WELWYN HATFIELD COUNCIL – DEVELOPMENT CONTROL
DELEGATED REPORT

APPLICATION No:	<u>S6/2007/401/FP</u>
------------------------	------------------------------

It is proposed to extend the existing first floor accommodation by increasing the height of the existing ridge line by approximately 0.5metres and therefore increasing the pitch of the side roofslopes. The existing front hipped roof is to be changed to a gable end and two side dormers added. This would provide accommodation for 2 bedrooms, a bathroom and a dressing room.

Drawn GPS 8088/P/001 D

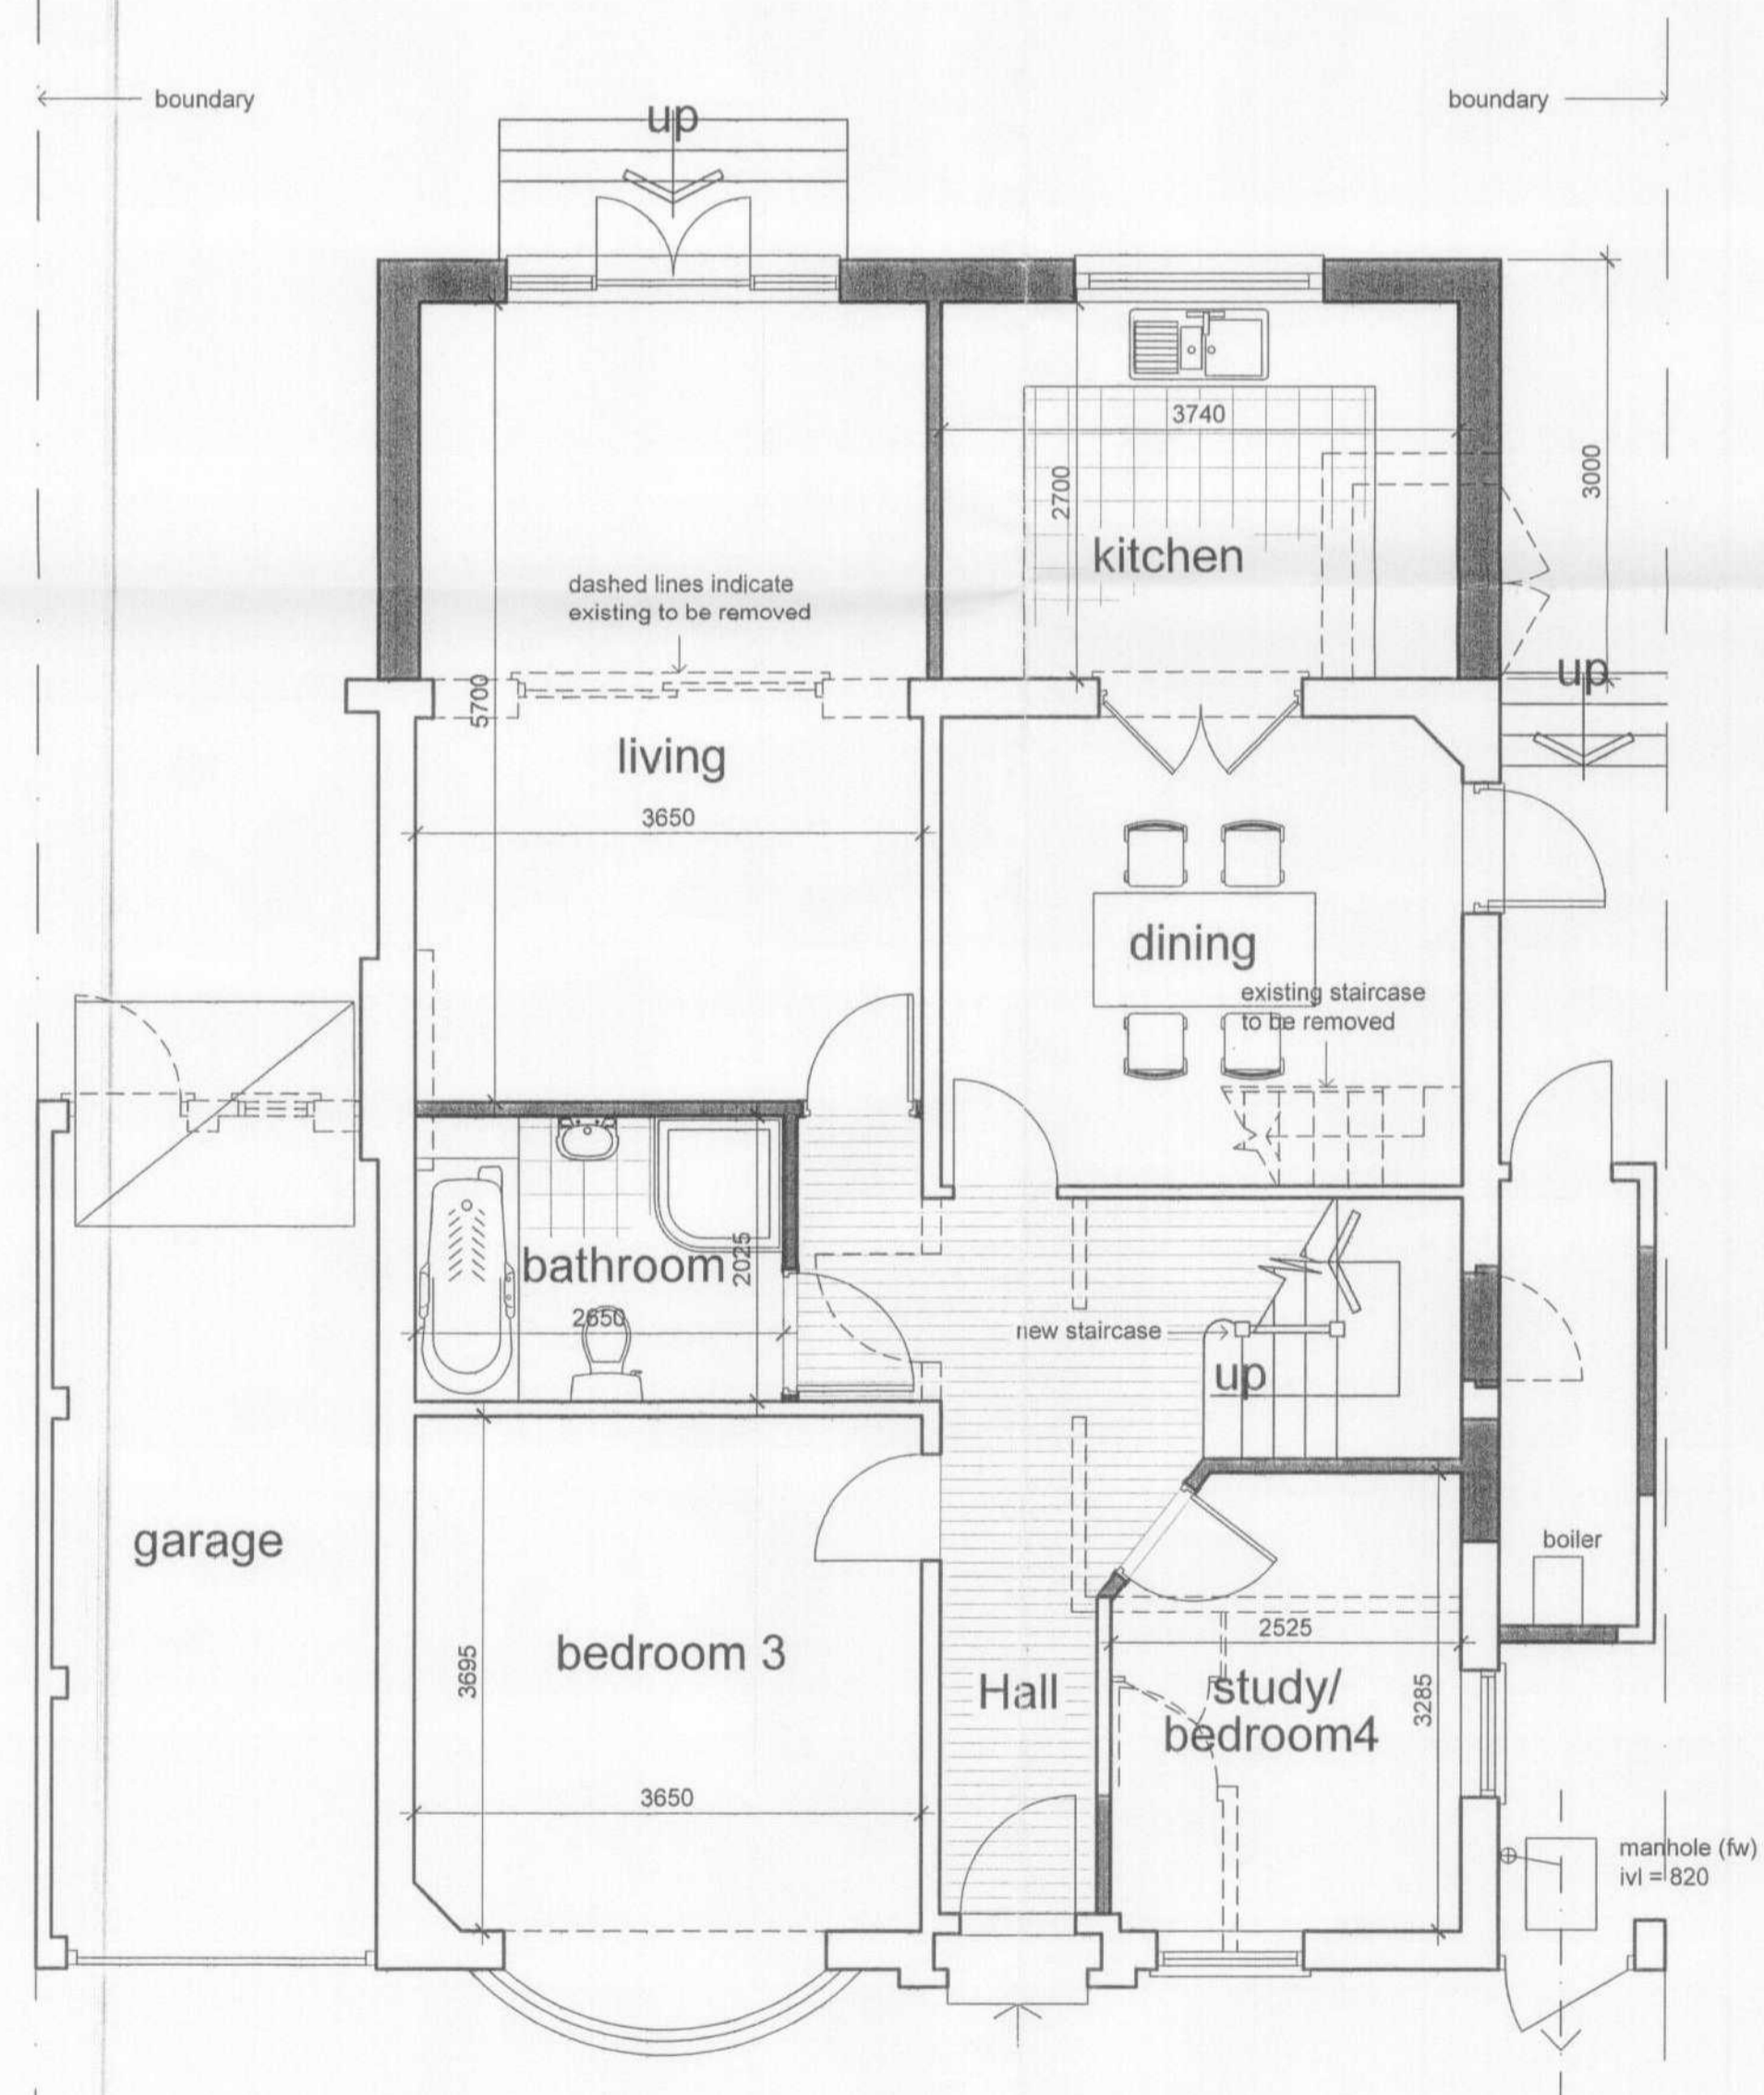
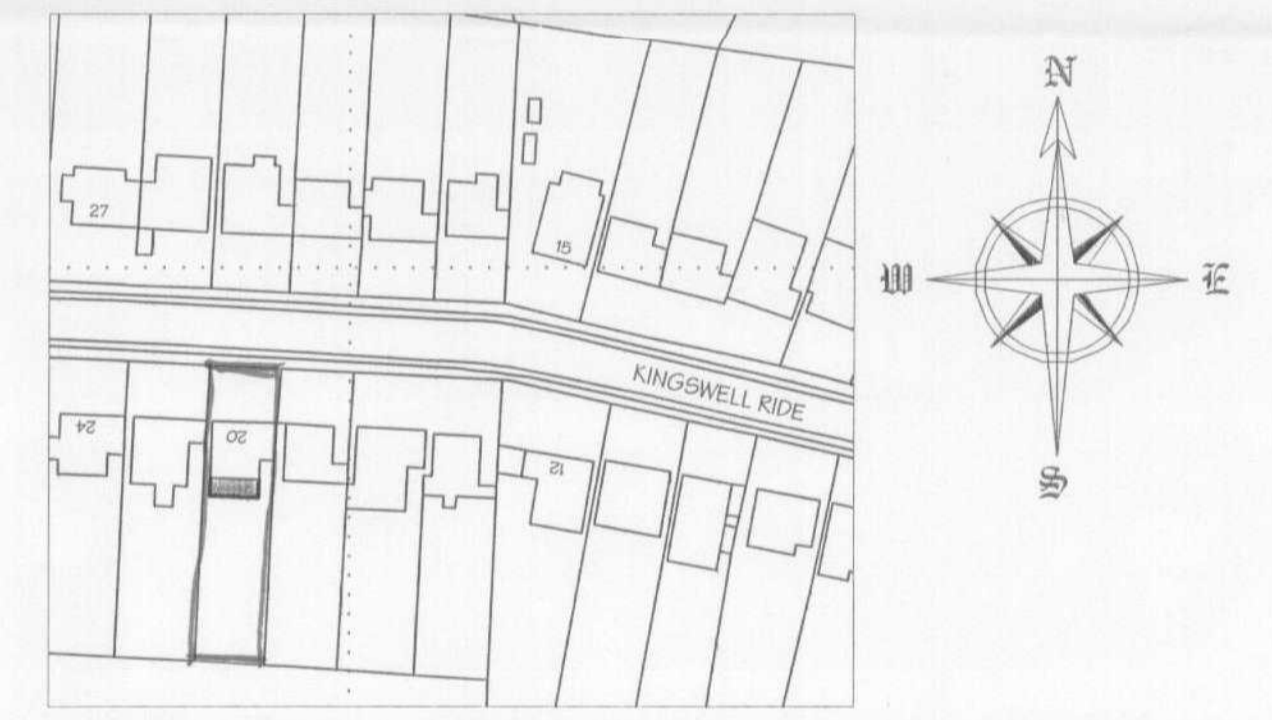
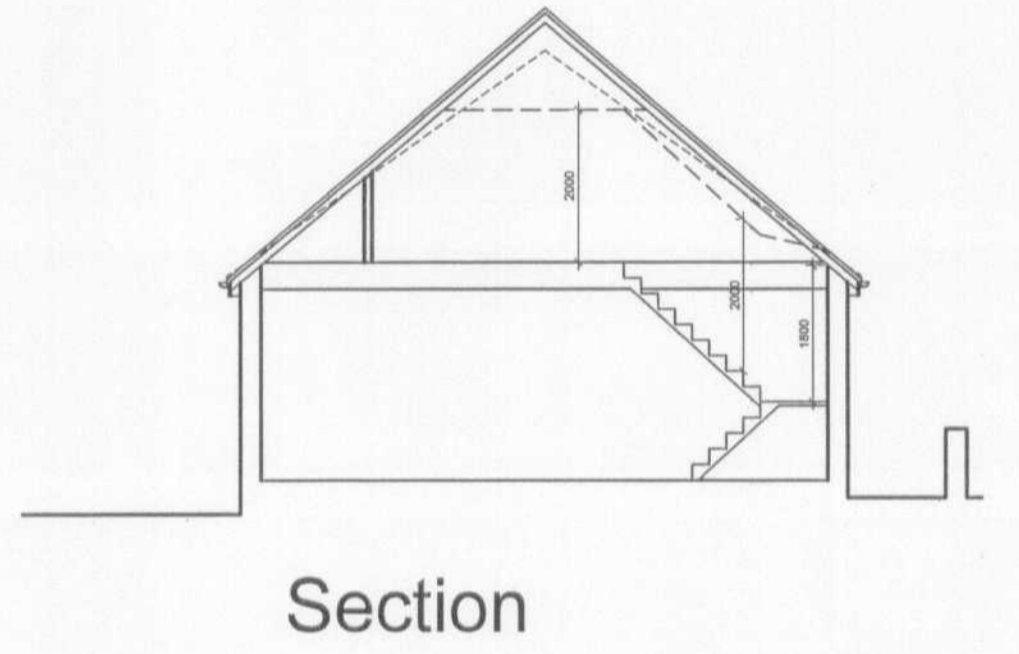
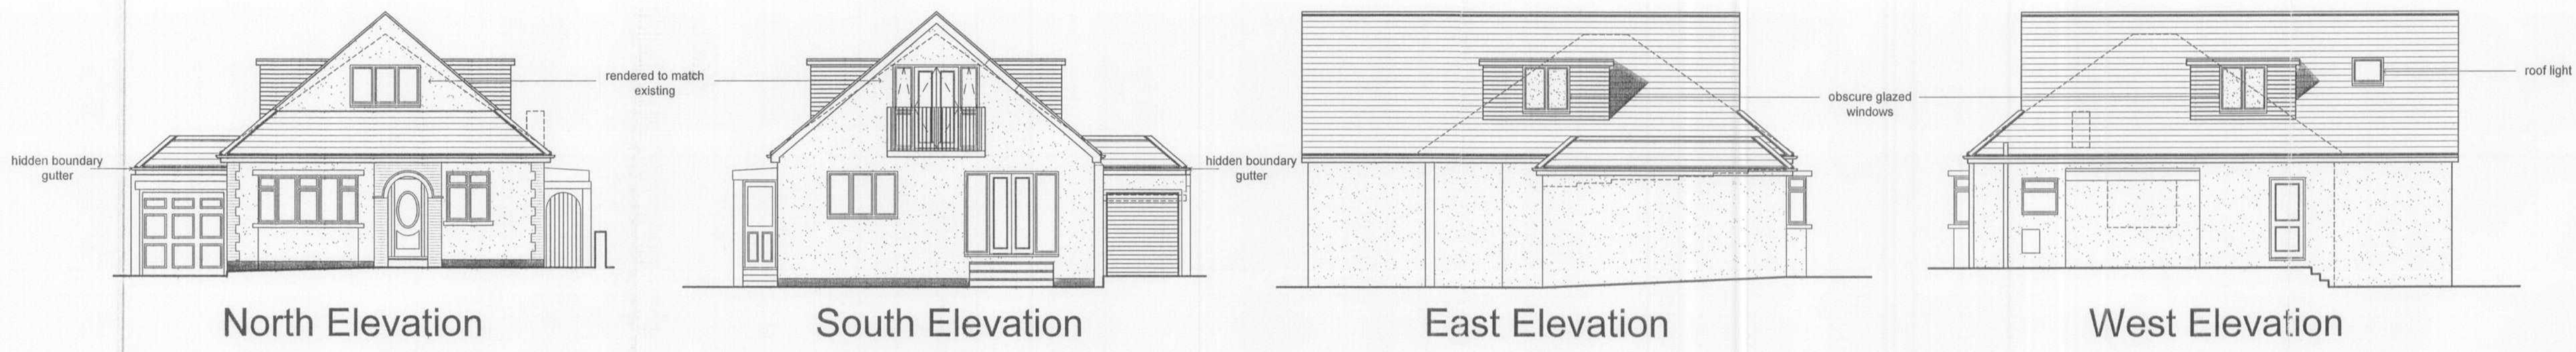
The proposed rooflight to the rear bedroom at first floor level would look over the roofslopes of adjoining residential properties and although these would result in only limited overlooking to these adjoining occupiers, good neighbourliness would expect these windows to be obscured glazed. A rooflight is proposed for the first floor rear bedroom which appears to be below eye level and would overlook the neighbours rear private amenity space. It would be reasonable to attach a planning condition to ensure that this rooflight is obscure glazed and non-opening below eye level. In addition, it would be reasonable to attach a planning condition to prevent the addition of further rooflights in the roofslopes without prior approval from the Local Planning Authority to ensure the amenity of adjoining neighbours is adequately safeguarded.

1. C.2.1 – Standard Time Limit
2. C.5.2 – Matching materials
3. The proposed rooflight to the master bedroom (as shown on approved drawing No.8088/p/001 Rev D) of the proposed building shall be glazed with obscured glass and shall be fixed so as to be incapable of being opened below a height of 1.7 metres above floor level, and shall be retained in that form thereafter.

4. The first floor windows to the bathroom and dressing room (shown on approved drawing No.8088/p/001 Rev D) of the proposed building shall be glazed with obscured glass and shall be fixed so as to be incapable of being opened below a height of 1.7 metres above floor level, and shall be retained in that form thereafter.
